Application No: EP/49/20/HH
Site Address: 45 The Ridings East Preston BN16 2TW
Description of works: Demolition of part of existing property. Construction of front, side and rear extensions.

Thank you for your internet representation made on 3rd June 2020 which has been recorded as an objection with the comments as follows:

The committee wishes to object to this Application on the following grounds.

REV.	DESCRIPTION	DATE
PROJECT	45 THE RIDINGS EAST PRESTON WEST SUSSEX BN16 2TW	
DRAWING TITLE	PROPOSED ELEVATIONS & STREET ELEVATION	
CLIENT	MRS J B SHULMAN	
SCALE	1:100 @A1	DRAWN BY FLB
DWG NO	935/P07	DATE APR 20
		REV. -

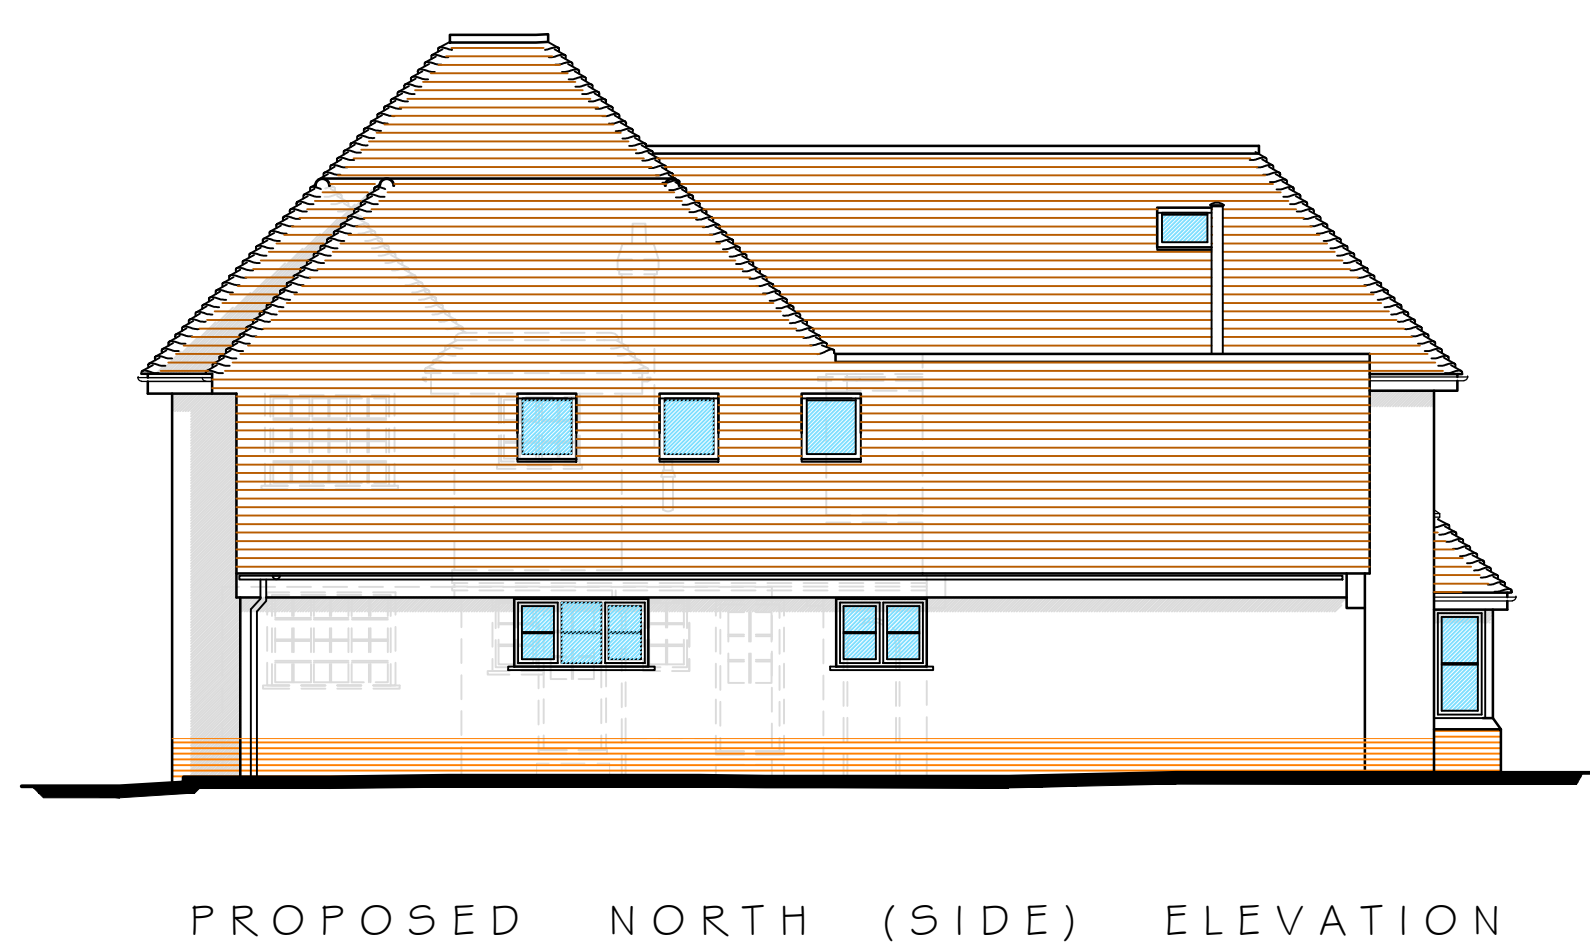
Removing a slice from the southern side of this house may result in an ungainly, lop-sided building. The existing property has a nicely-proportioned roofline which will be lost when the southern elevation becomes a gable end. It is believed this could have a negative impact upon the streetscene. We believe this would be contrary to Policy D DM1 of the Arun Local Plan and the East Preston Neighbourhood Plan.

DRAWING TITLE
PROPOSED SITE LAYOUT

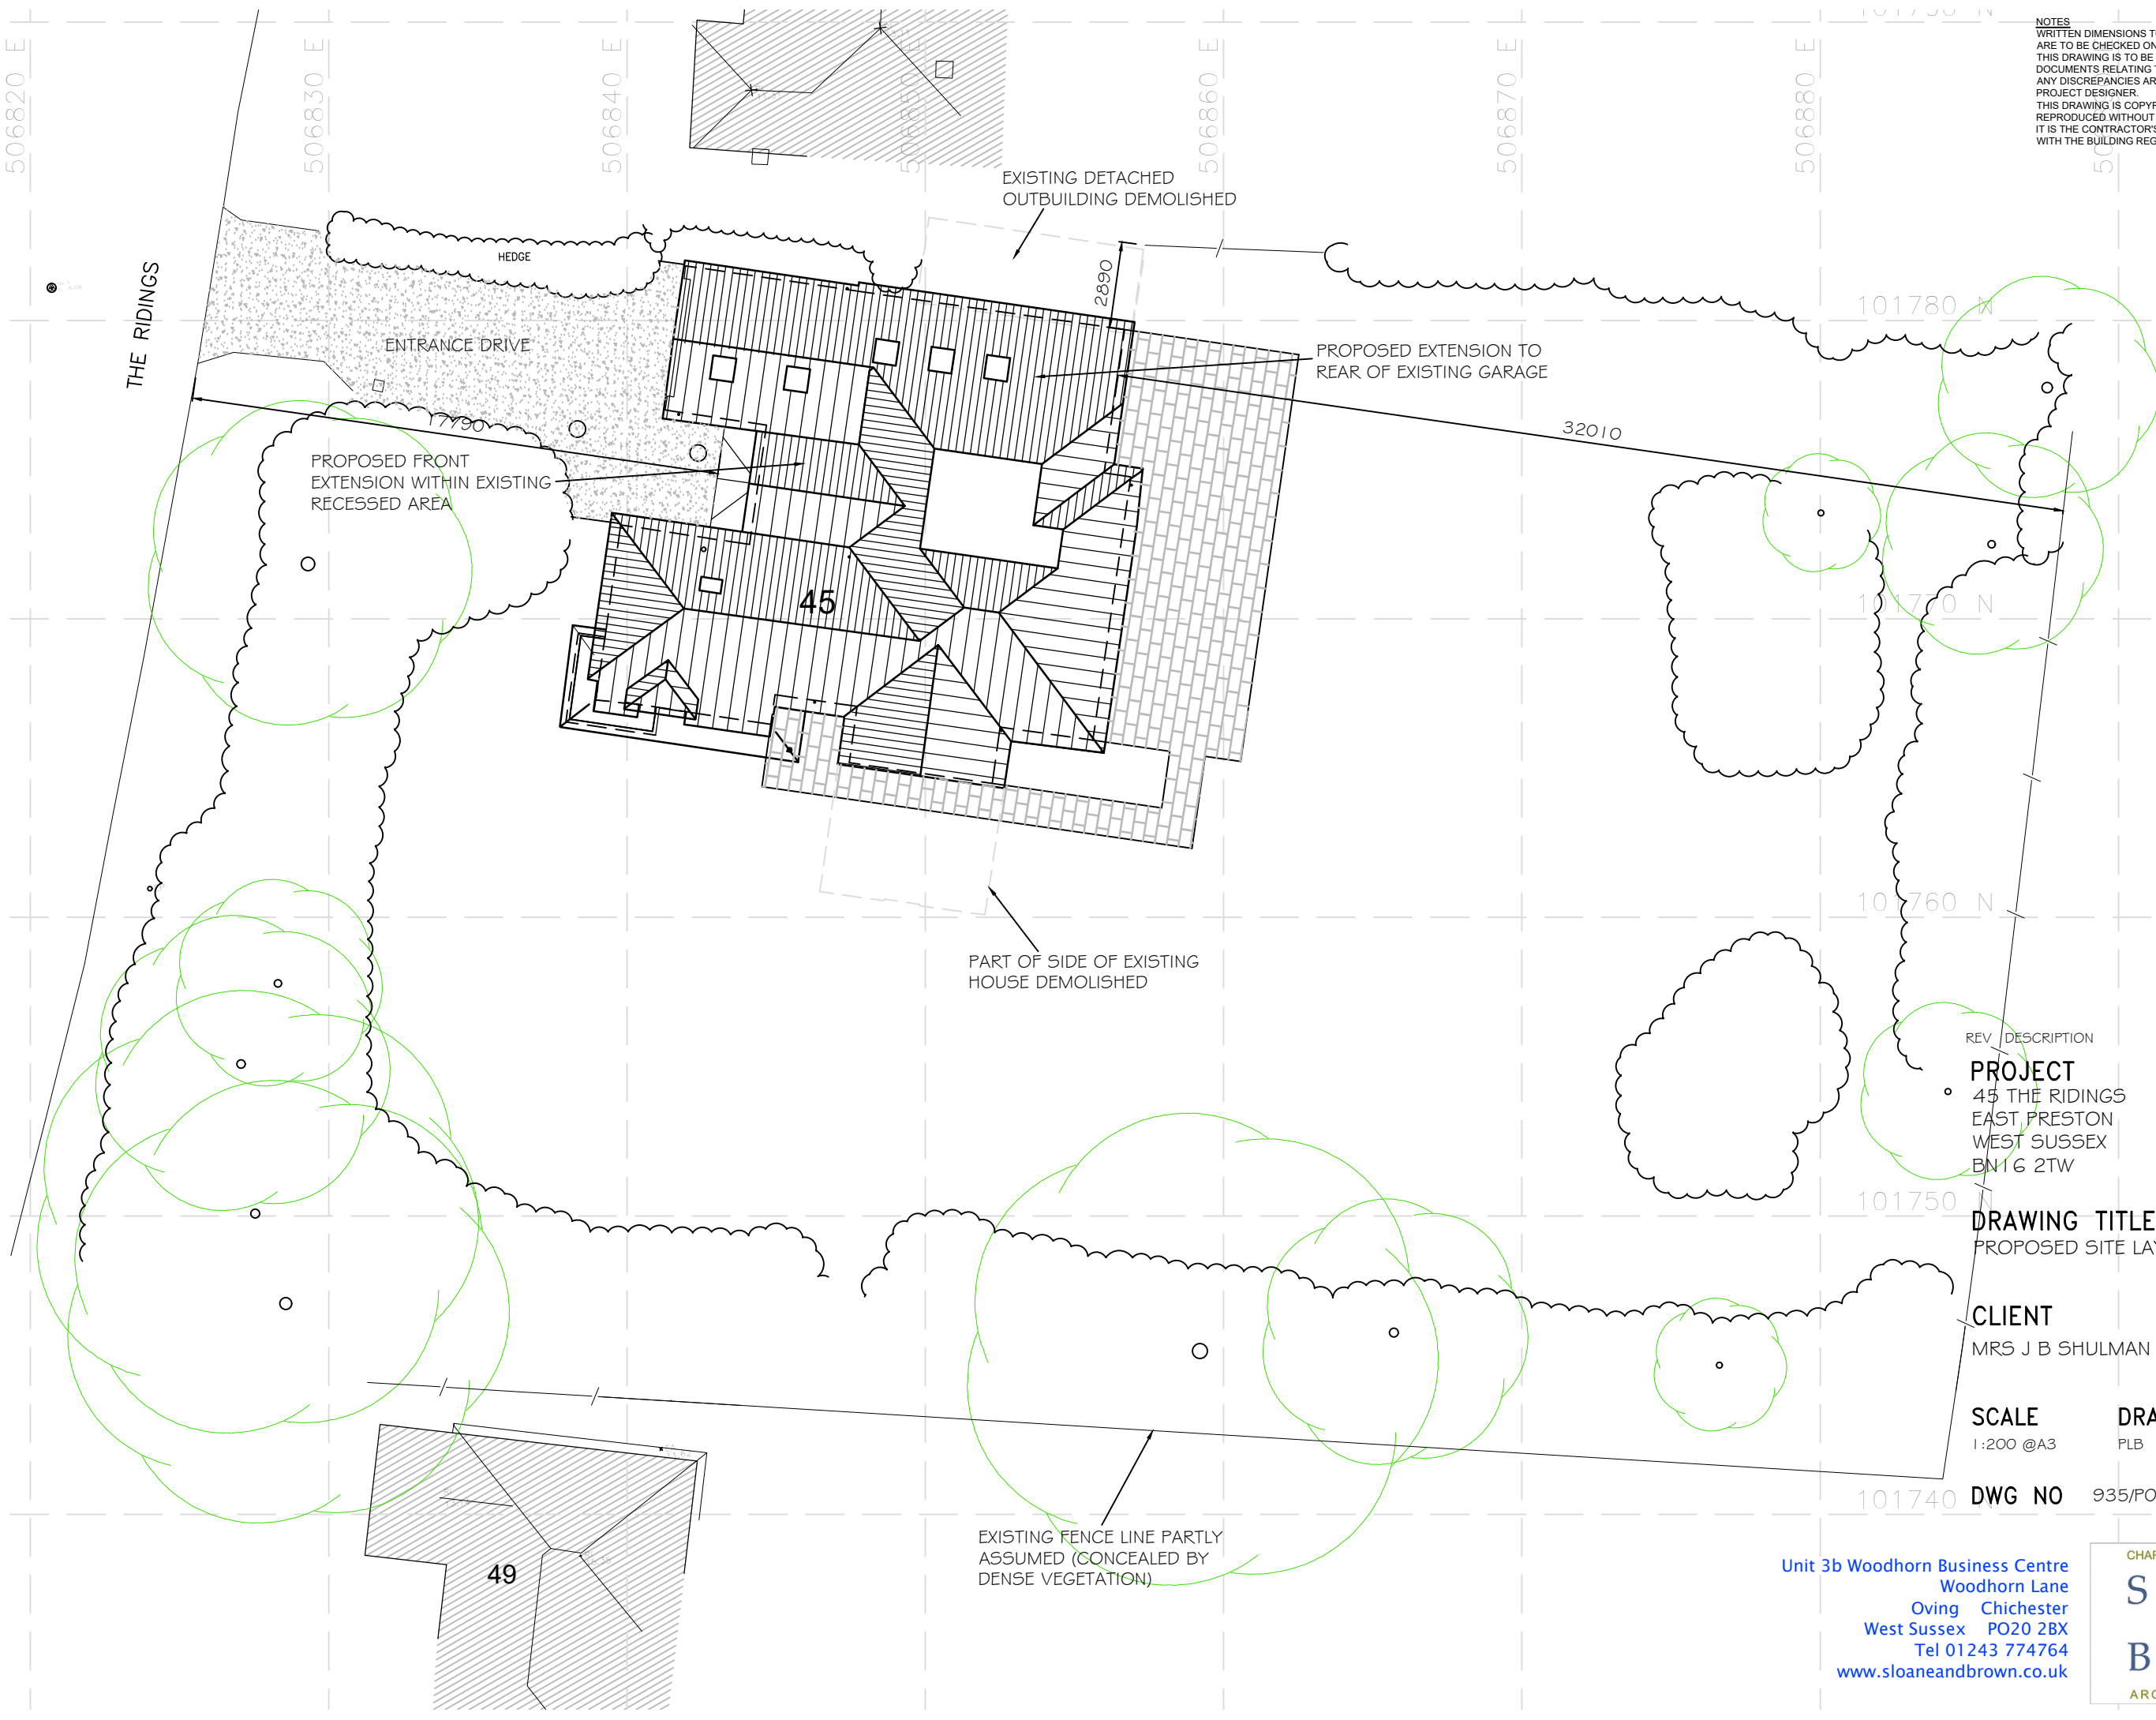
This council would also be concerned about any boundary between this property and the rest of the plot being too close to this property should such a division of the existing site be forthcoming. This could also have a negative impact upon the streetscene.
